Our ref: DOC21/65477

Senders ref: SSD 5248 MOD 1 (Fairfield City)

Subject: Gazcorp Industrial Estate Modification 1 Revised Layout and Earthworks, 813-913 Wallgrove Road, Horsley Park (SSD 5248)

EES have reviewed the Modification Report prepared by Ethos Urban dated 23 December 2020 and relevant documents and make the following comments:

Figure 6 | SSD-5248 Proposed Stage 1 Bulk Earthworks

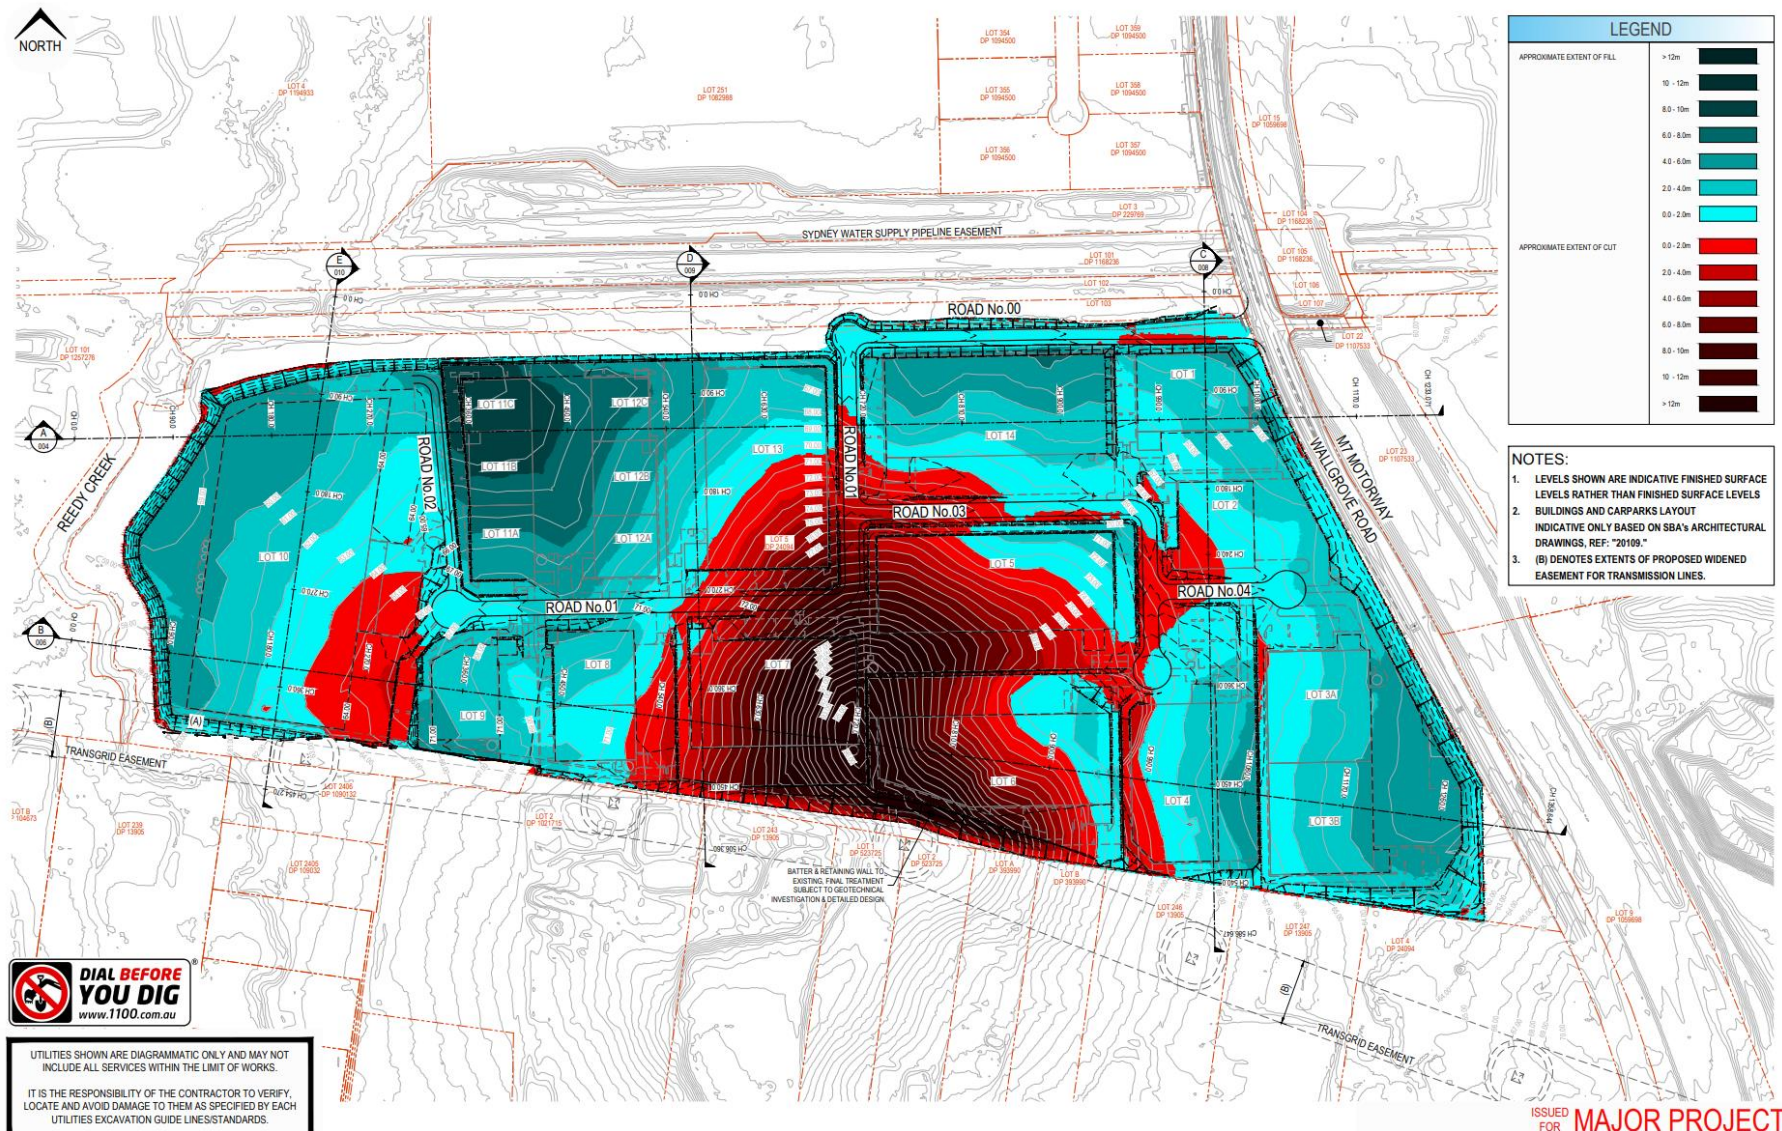
The development site will accommodate 14 industrial lots in the post-developed conditions. The footprints of the industrial lots within the development site indicate that the western and north-western sides of Lot 10 would approach into the floodplains of the Reddy Creek Catchment.

The filling activities in those locations of Lot 10 are likely to impact the existing floodplain storage. The section of Reddy Creek in these locations (adjacent to Lot 10 and upstream of bulk water pipelines) would become a hydraulic bottleneck, which would have adverse flooding impacts at Lot 10 and the upstream catchment areas. The extent of the impacted area within the floodplains and the quantification of floodplain storage loss can be ascertained by comparing the regrading footprint (Civil Drawings) with the flood map of an 1% AEP Flood Event (Rural Areas Flood Study).

EES recommends that the proponent undertake a comprehensive analysis by using the flood models for the Reddy Creek Catchment to evaluate storage loss in the floodplains and flooding impacts at Lot 10 and its adjoining areas in order to identify the appropriate measures to mitigate adverse flooding impacts in the post-developed conditions of the development site.
